Ribble Valley Borough Council
Council Officers, Church Walk
Clitheroe
BB7 2RA

Your ref: 3/2012/0669
Our ref: DC/12/4501
Date: 30-NOV-12

Location: Land at Lincoln Way Clitheroe

Proposal: Full Application for the proposed erection of an industrial unit and alterations to parking

PROPOSED PLANS, ELEVATIONS AND SITE PLAN

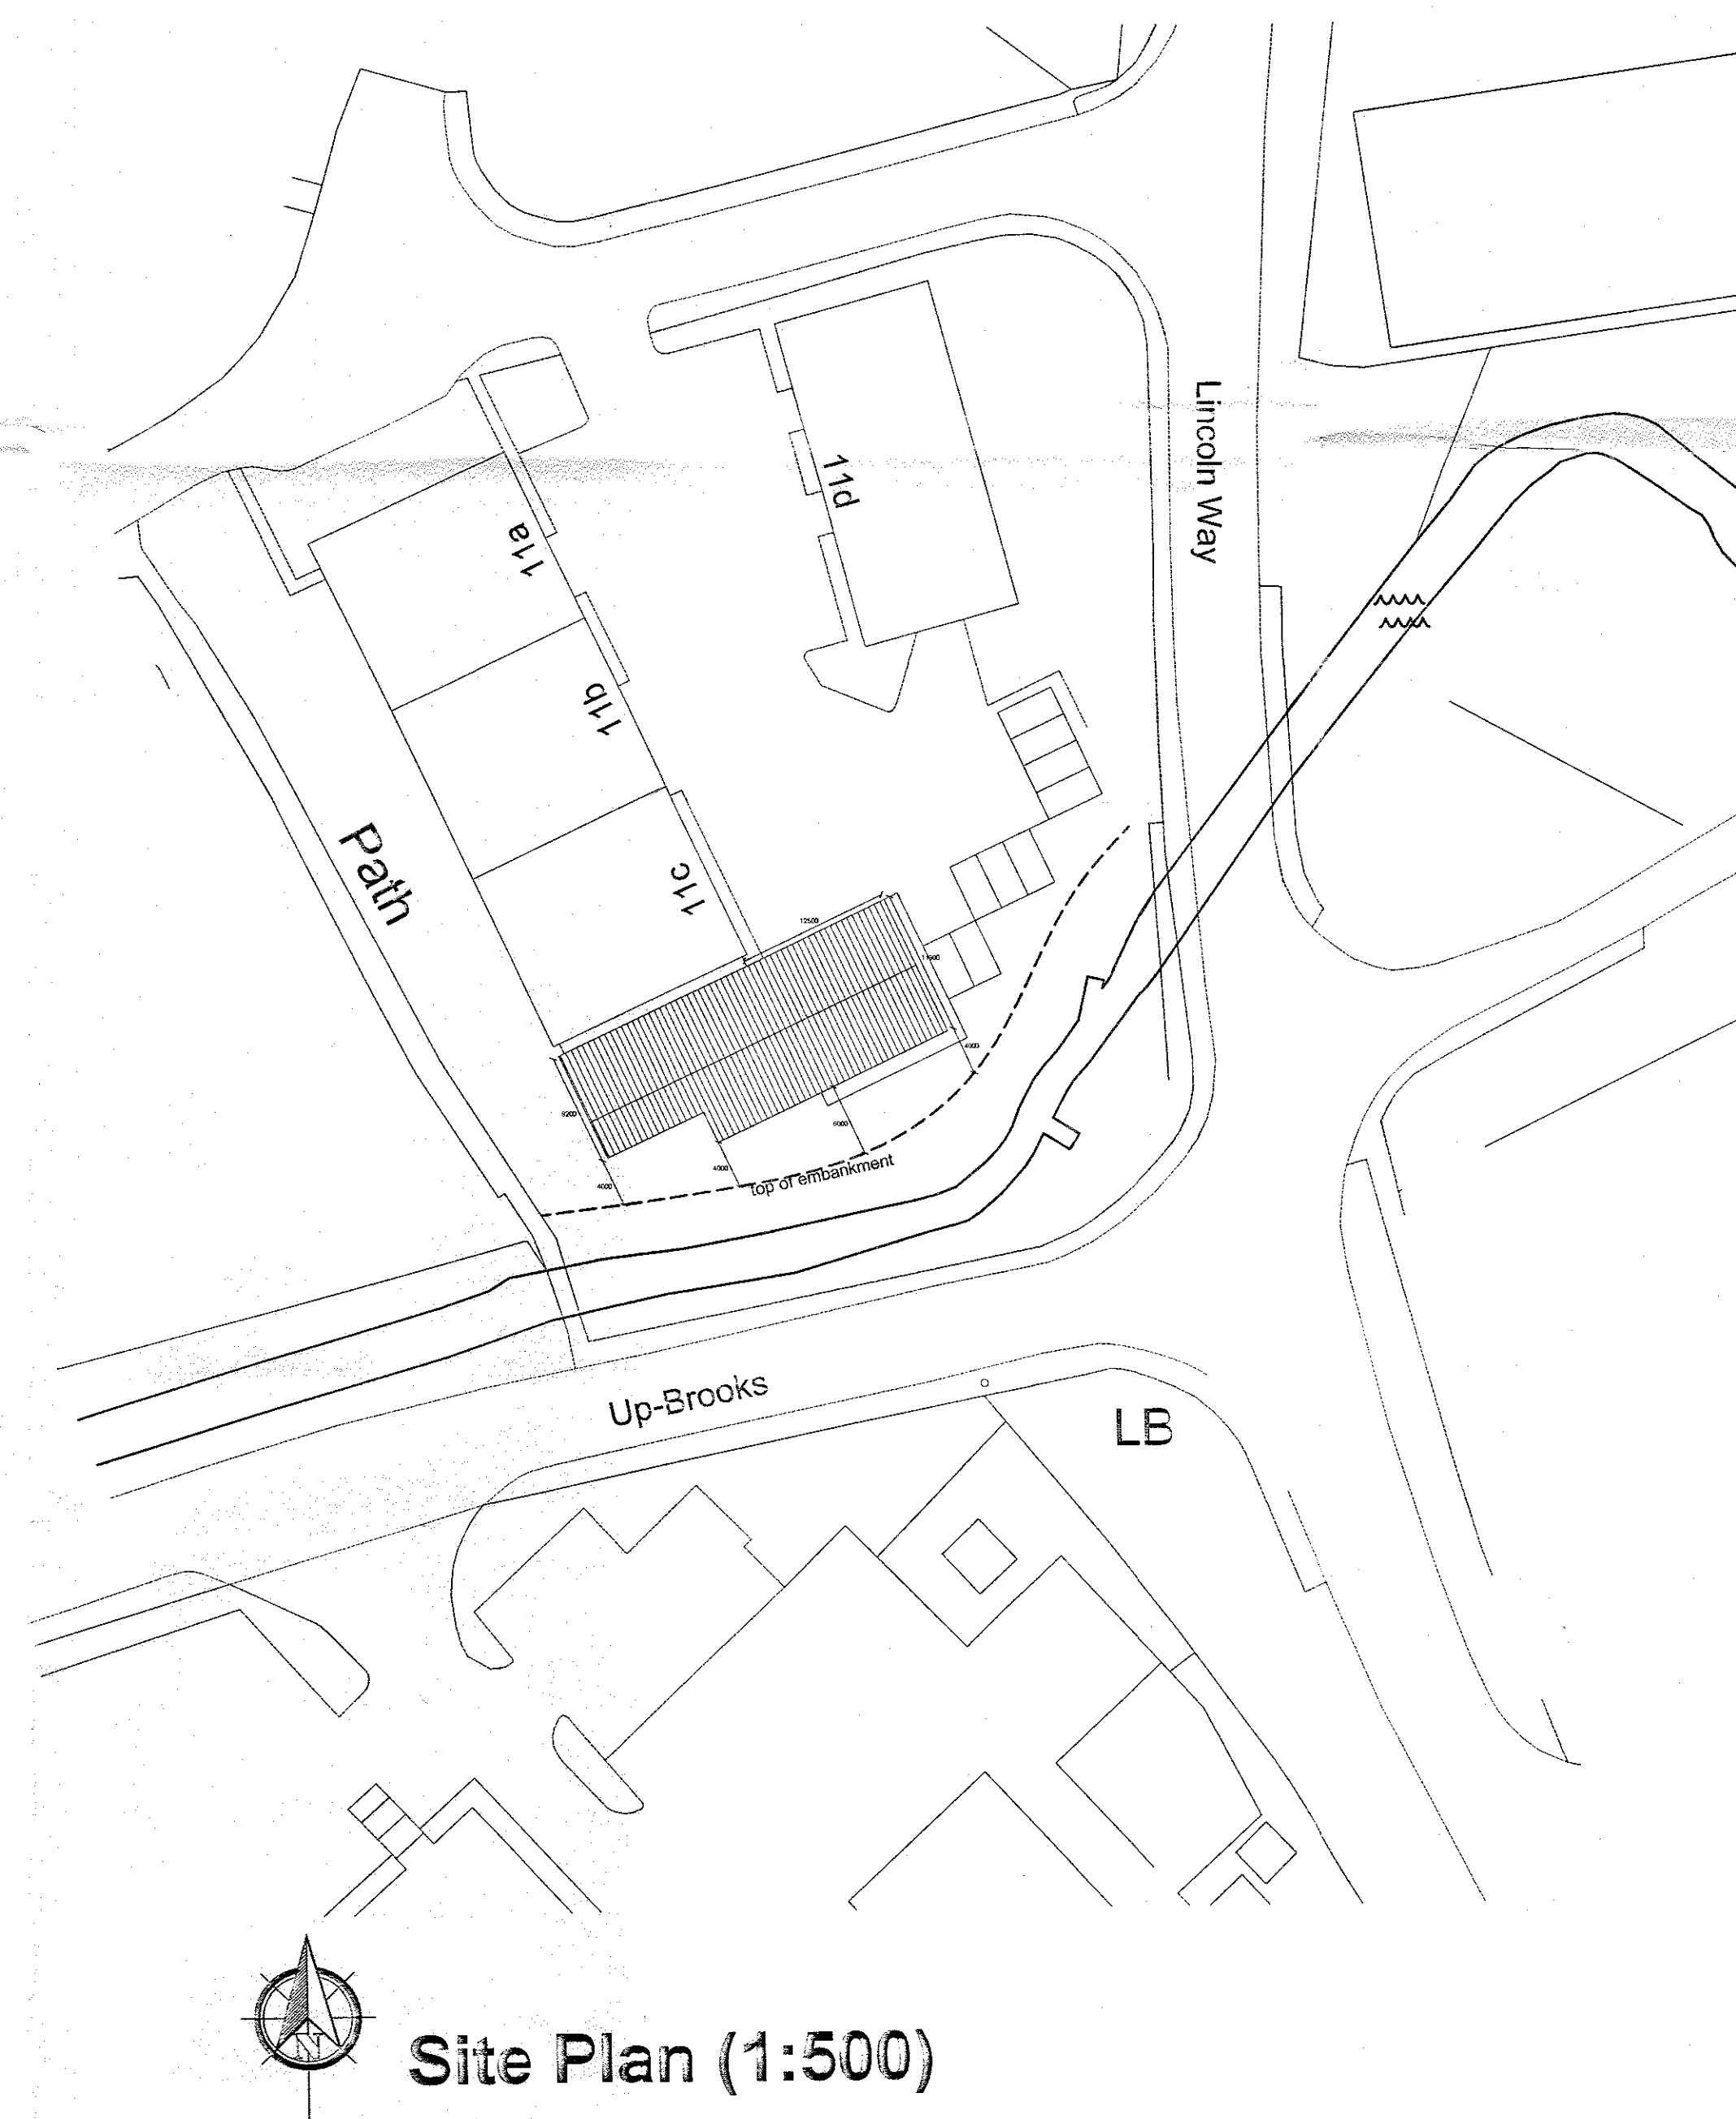
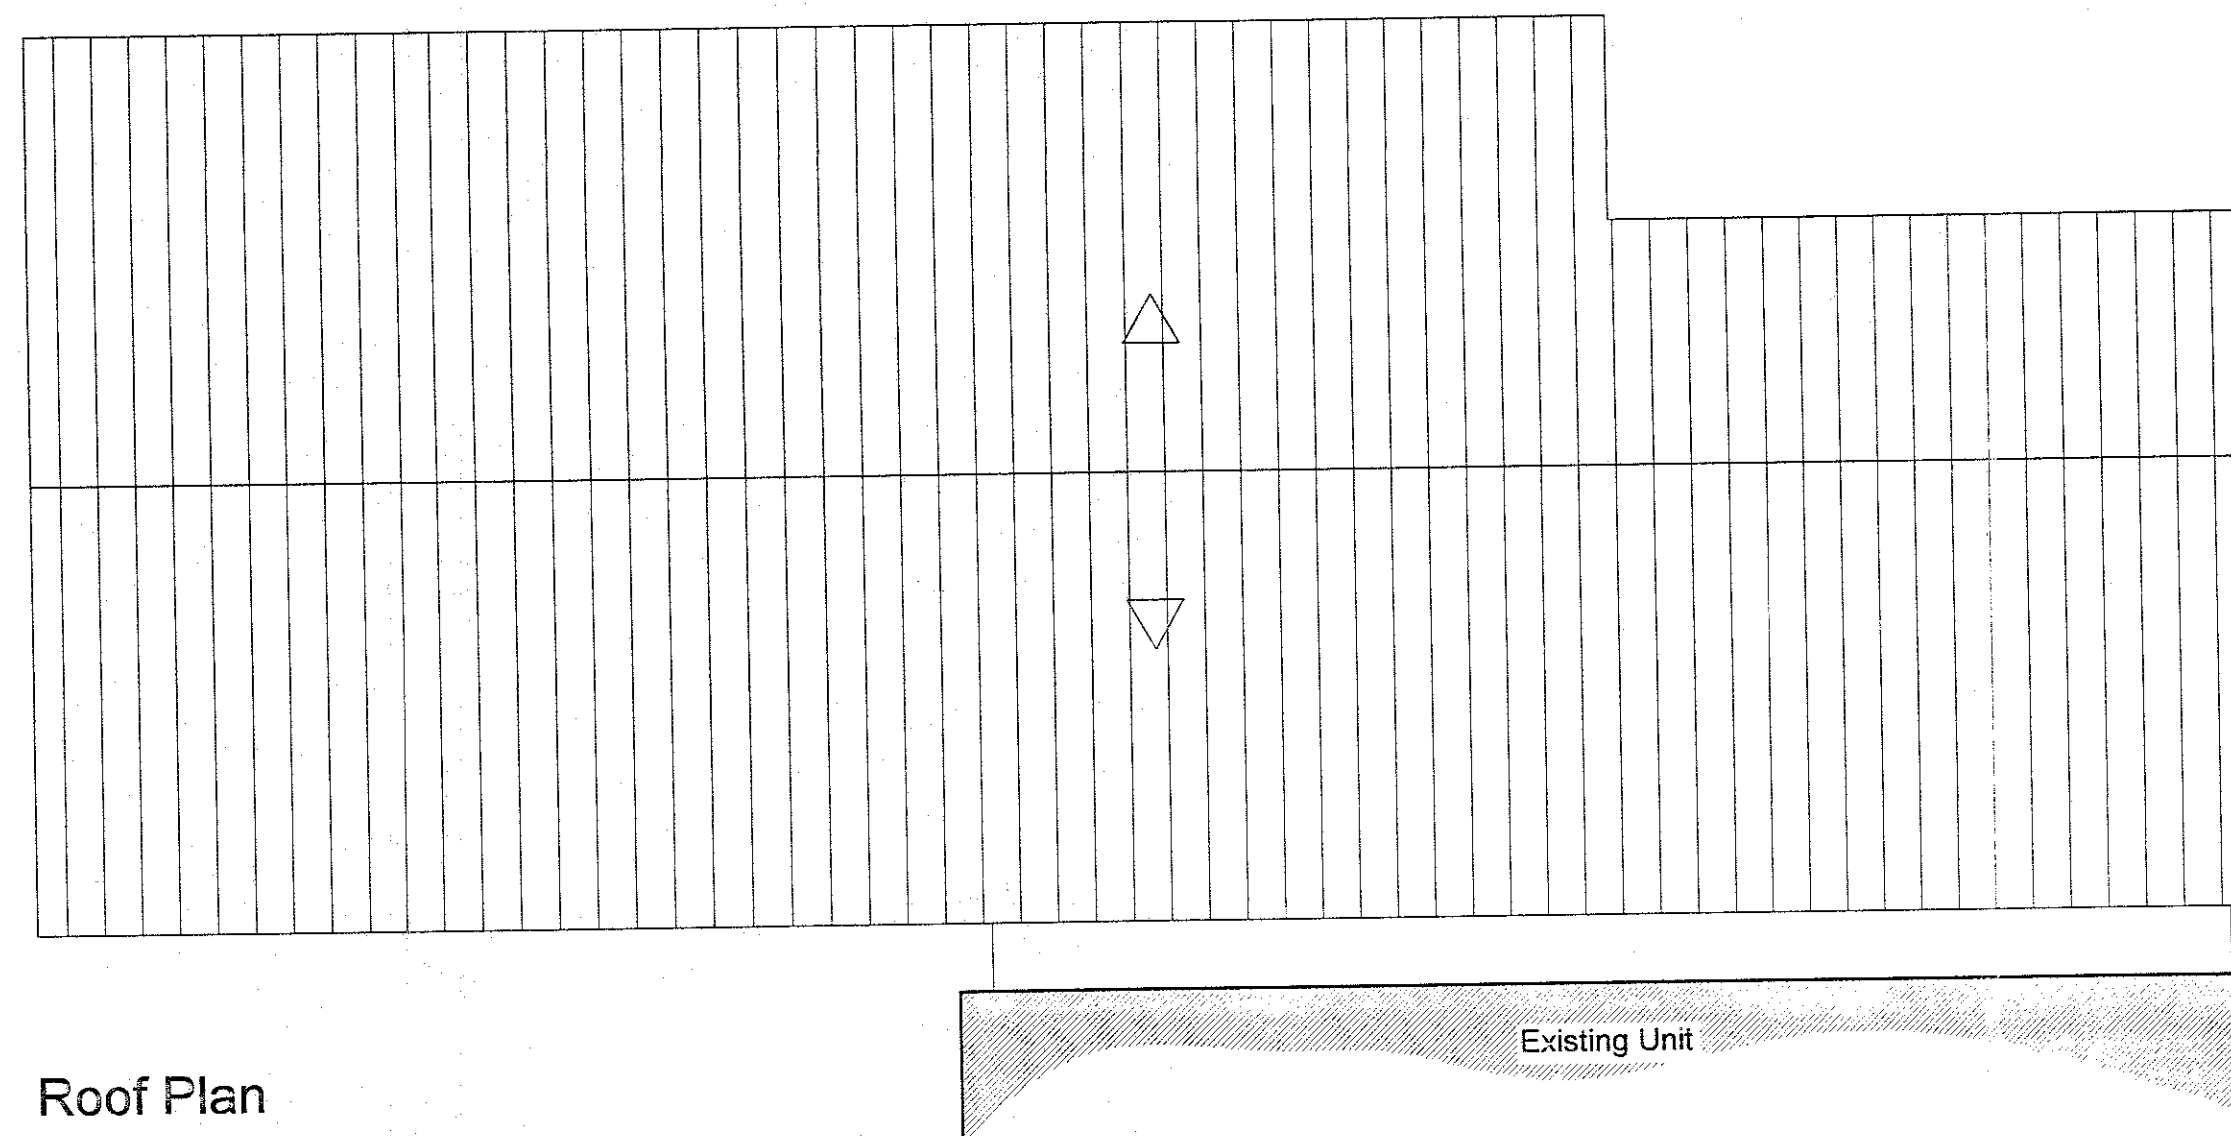
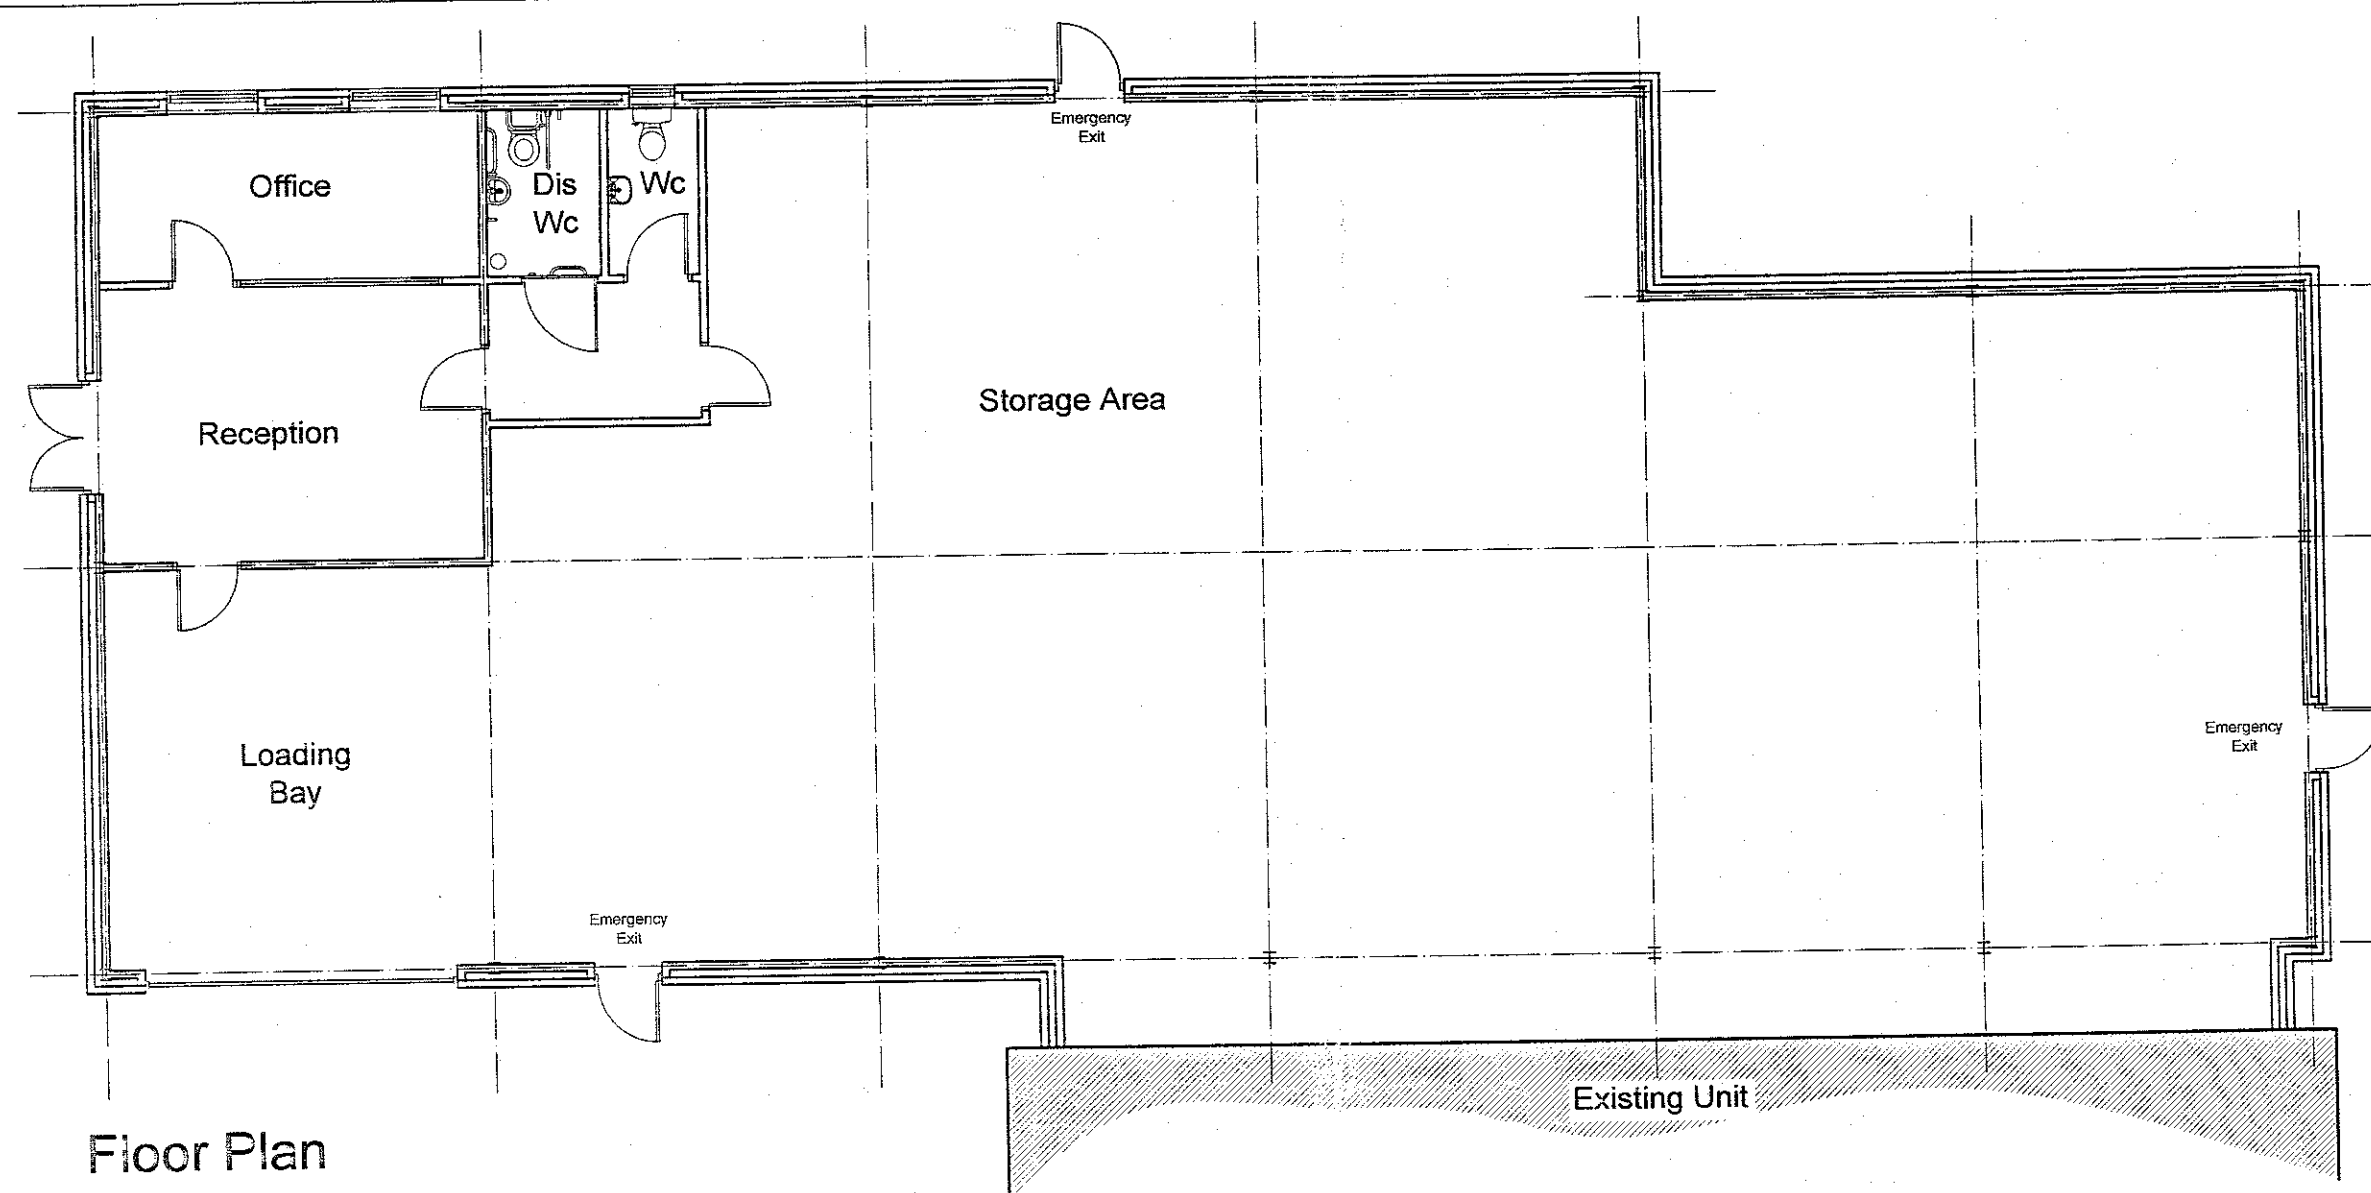
A public sewer crosses this site and we will not permit building over it. We will require an access strip width of 6 metres, 3 metres either side of the centre line of the sewer which is in accordance with the minimum distances specified in the current issue of "Sewers for Adoption", for maintenance or replacement.

Therefore a modification of the site layout, or a diversion of the affected public sewer at the applicant's expense, may be necessary.

- Notwithstanding any indication on the approved plans, no development shall be commenced until a scheme for the diversion of existing sewers, ensuring that the diverted sewer is not within 3m of the proposed building or river bank, has submitted to and approved in writing by the Local Planning Authority. The development shall be completed, maintained and managed in accordance with the approved details.
